SOUTH HOLLAND DISTRICT COUNCIL

To: Planning Committee - 14 December 2022

Purpose: To consider Planning Application H16-0903-22

Description: Proposed Glasshouse Development

1540-1_PLP
Pipe A and Pipe B Location Plan

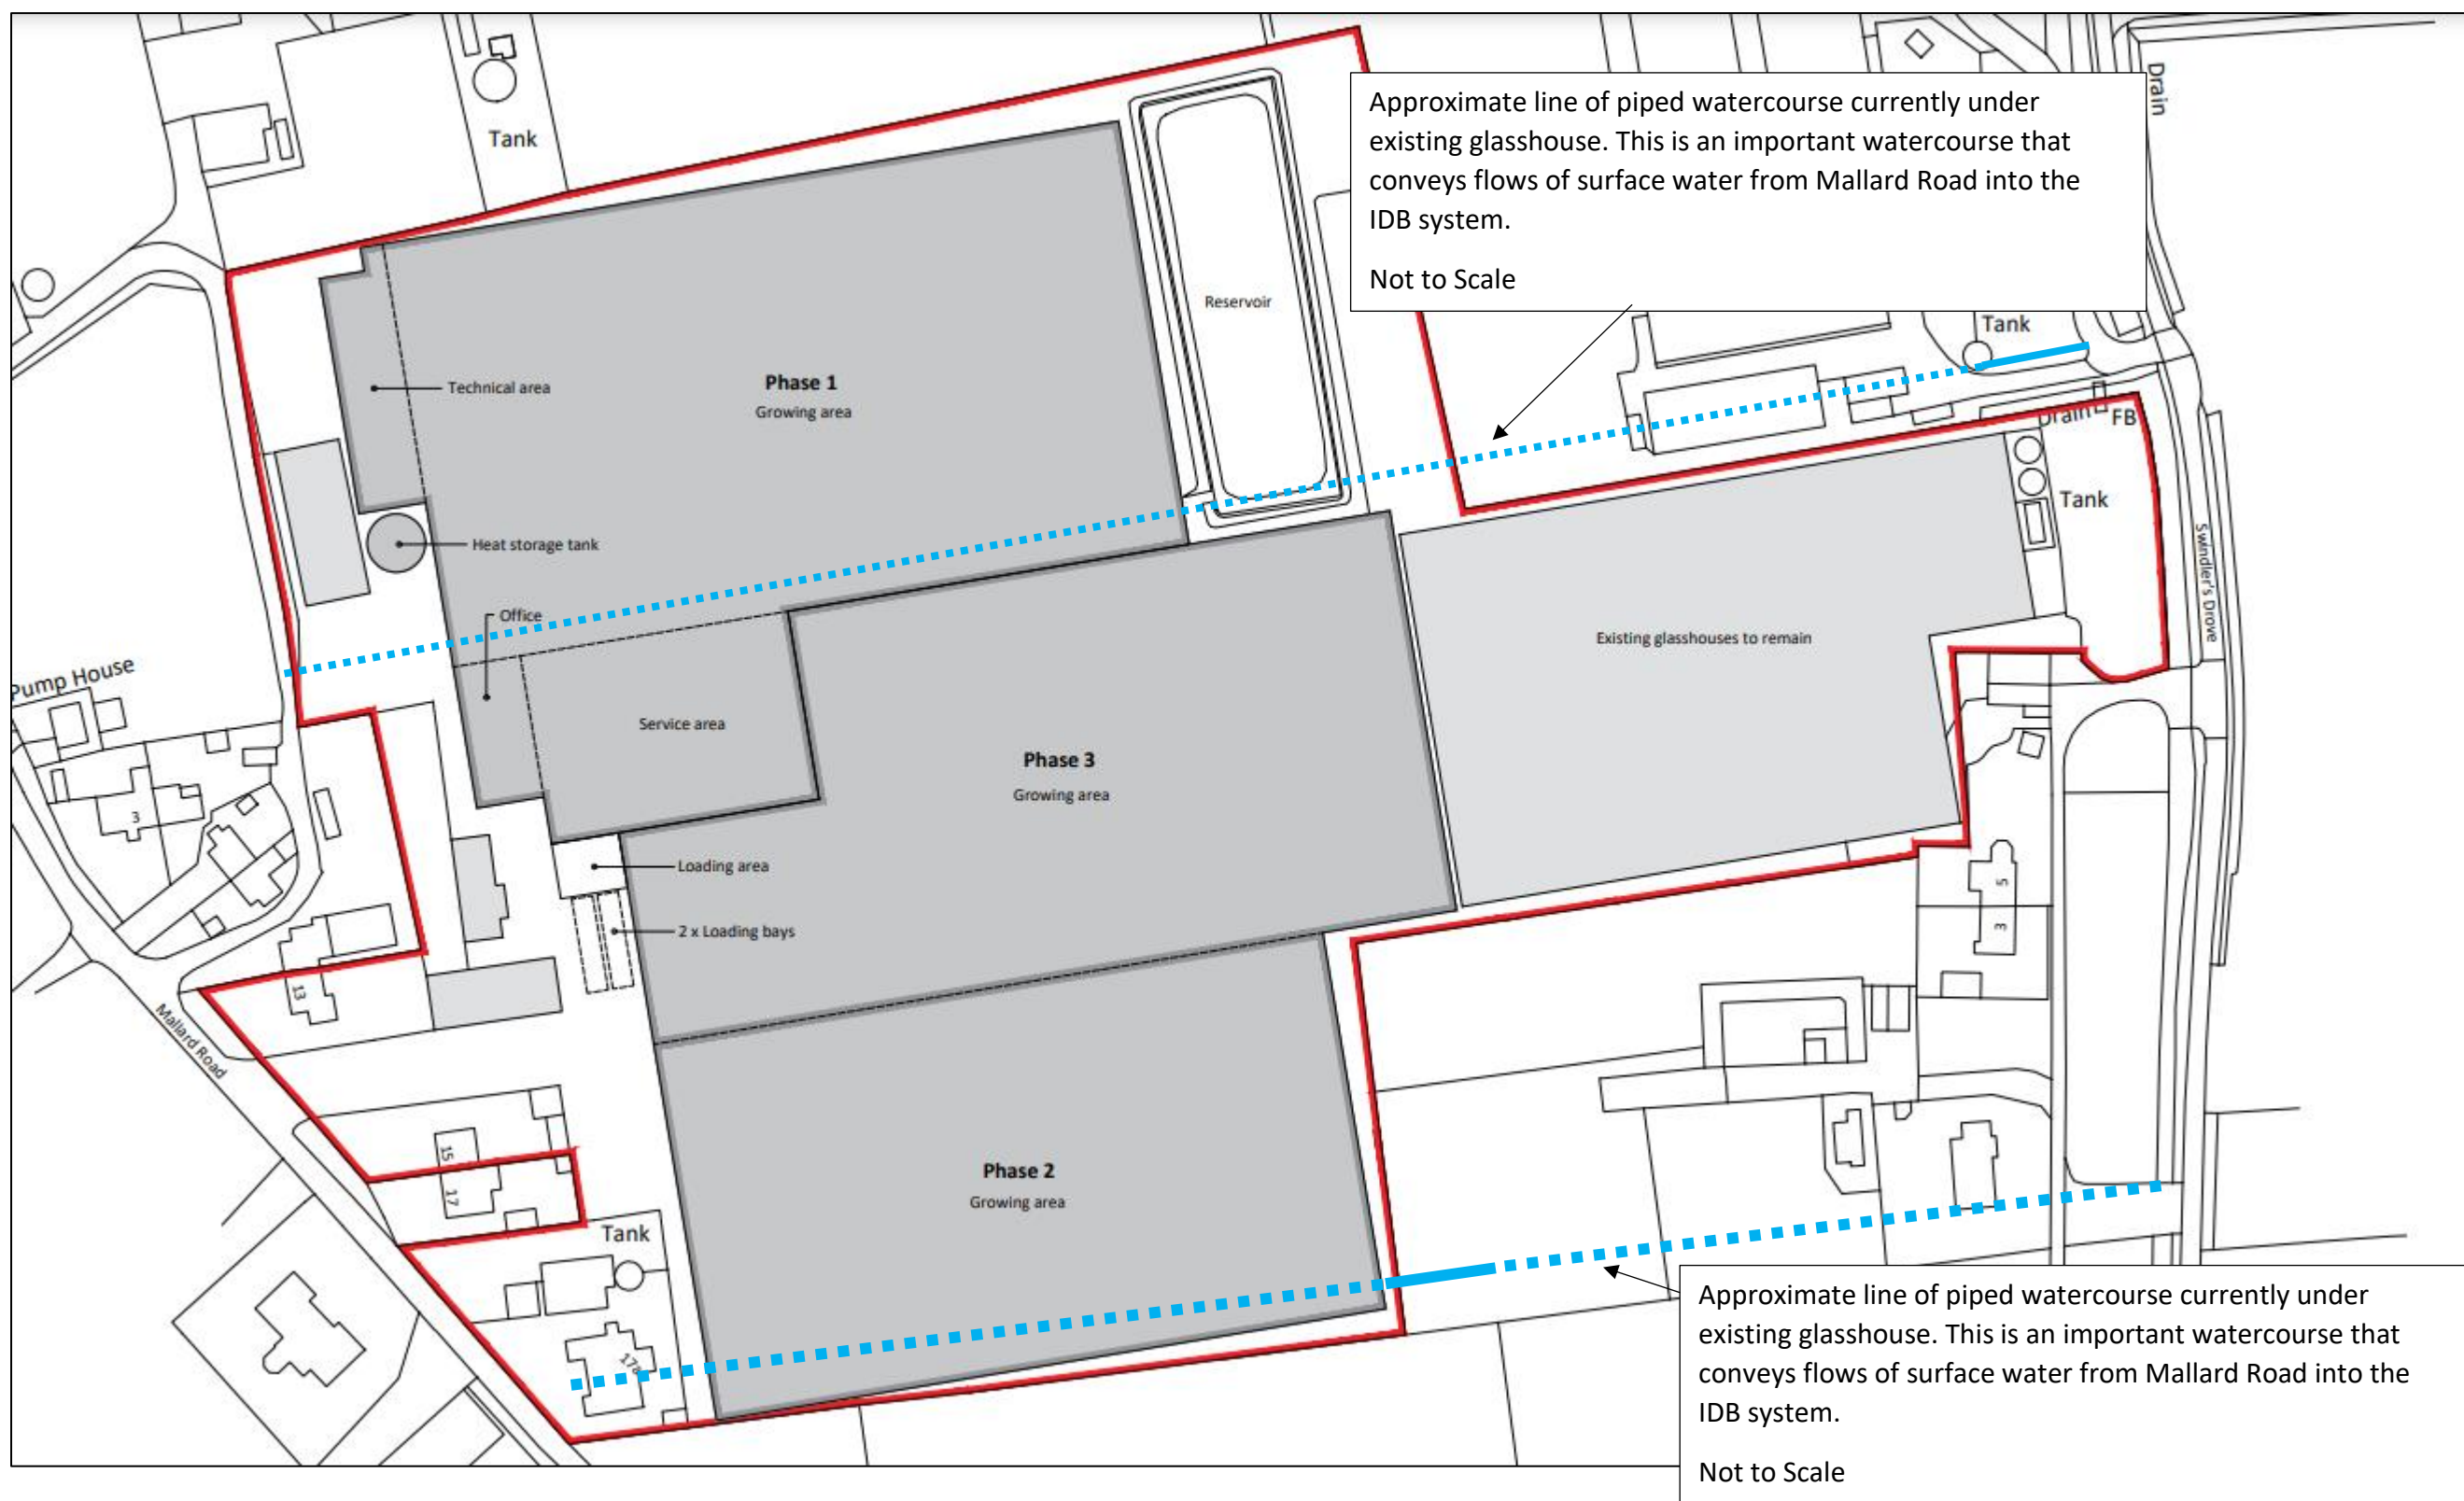
7.31 The IDB has identified that through the site there are two pipes that run underneath the site that, if inspected, repaired if necessary, could contribute positively to minimising flooding in the area.

- the results of a camera survey of pipe A and Pipe B that traverse the site as shown on plan reference 1540-1_PLP submitted on 23rd November 2022 together with any other pipework that may be discovered, in the course of the survey, to connect into pipe A and/or pipe B.

7.32 A pre-commencement planning condition is suggested which seeks a comprehensive surface water drainage scheme which seeks to examine and repair (if necessary) the drainage pipes that run through the site, calculate how much on site water storage is needed proportionate to the surface area of the greenhouses, calculate how much water would be recycled, and calculate how much additional storage is needed due to storm surges, so that flooding of surrounding areas is not significant. Development could not begin until the scheme is submitted and approved by the Local Planning Authority. Subject to the imposition of the condition, it is considered that the impacts of the proposals and the concerns of local residents in relation to flooding and surface water, can be mitigated. As a result it is not considered that the proposal would be in conflict with Policy 4 of the SELLP.

Drawing No.
 1540-1_PL_ELO1

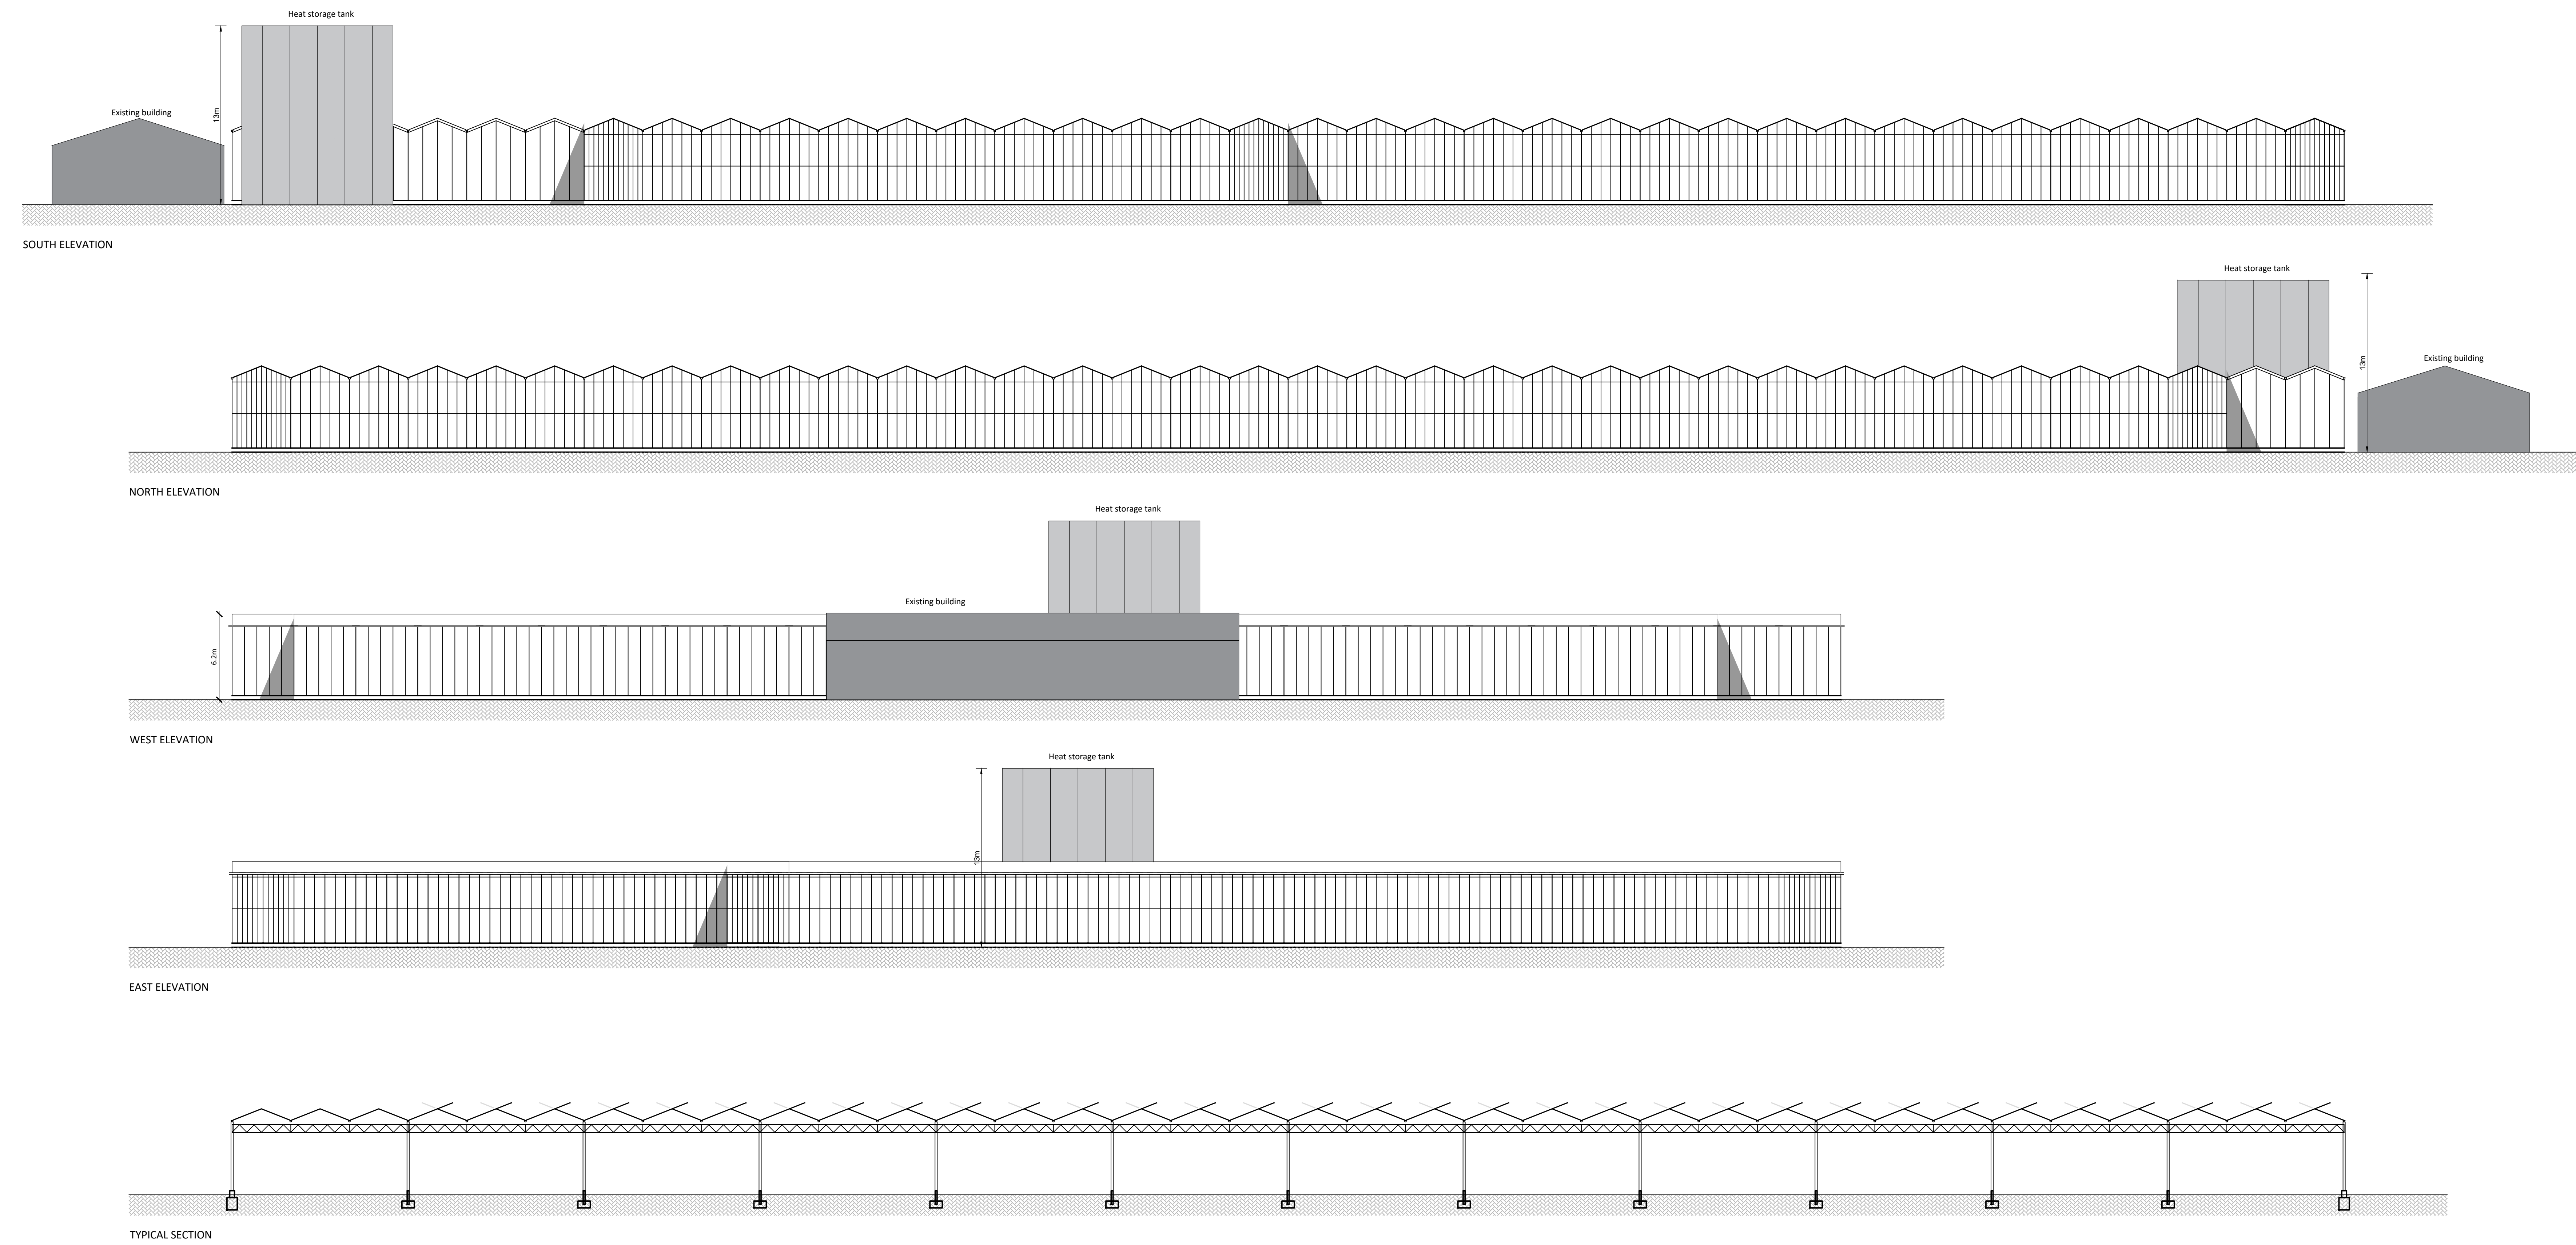
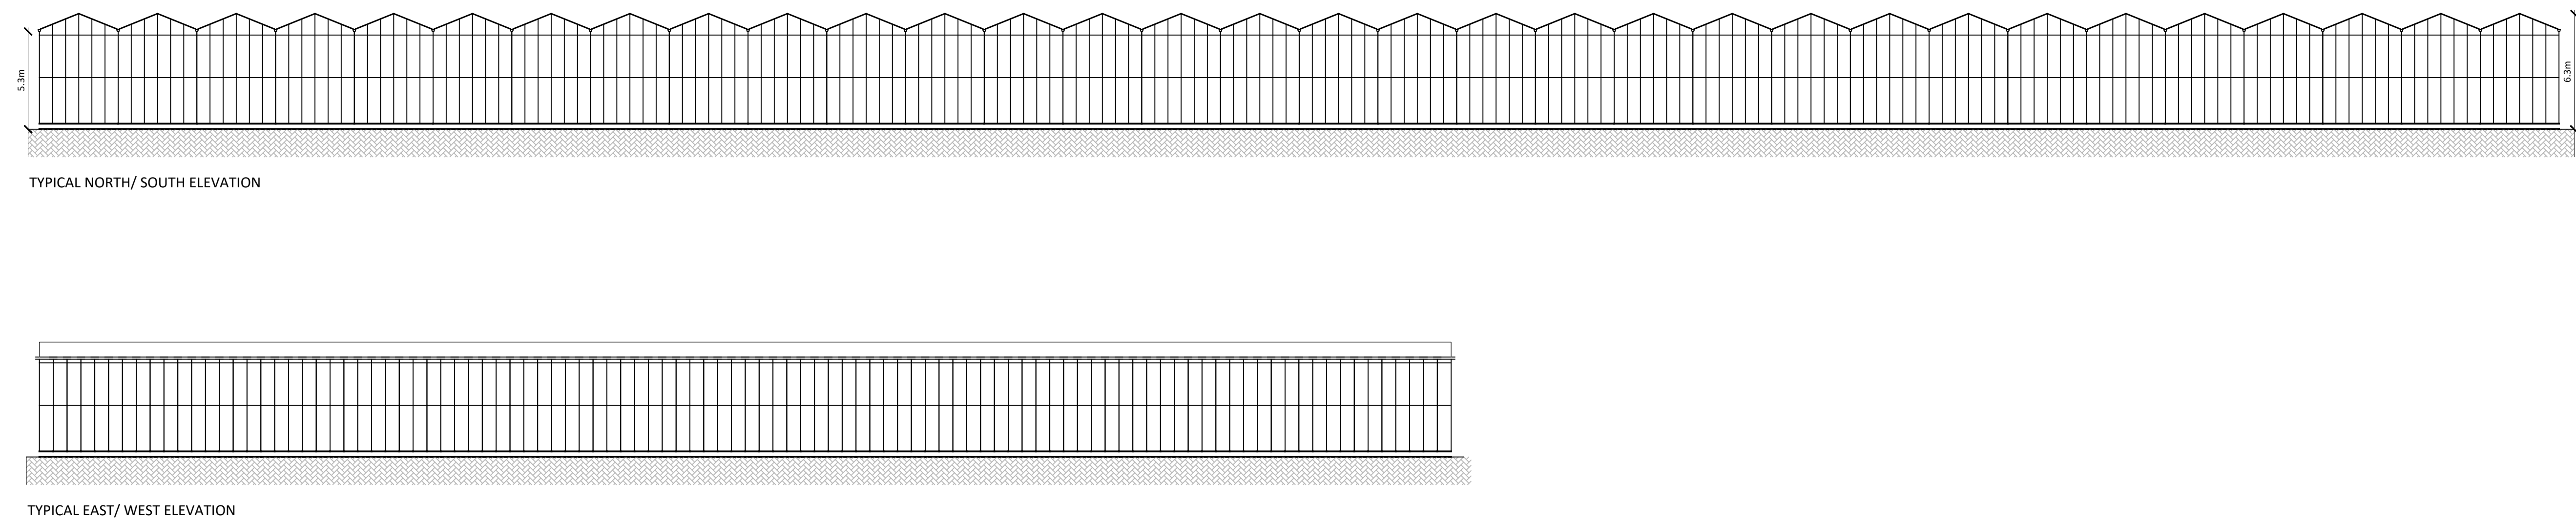
7.16 The glasshouses would be of an increased height with 6.2m in height in phase one and 5.3m in phase 2. Whilst the height of the glasshouses are increasing it is not considered that the increase would adversely affect nearby neighbouring dwellings due to the distances away from the glasshouses. The design in terms of external elevations would be an improvement to the existing glasshouses as they are being renewed with more modern materials.

7.17 One objection relates to the overshadowing effect of the 13m high water tank. This is acknowledged and taken into account. However, the water tank will be partly shielded from Mallard Road as a result of its location directly next to the Biomass boiler building. Whilst it will be visible in the street scene, given the character of the area it is not considered that the water tank would lead to overshadowing given its location in the site and distance away from neighbouring buildings. As there are numerous industrial style buildings along Mallard Road, it is not considered that the water tank would look out of keeping with the surroundings or significantly affect landscape character.
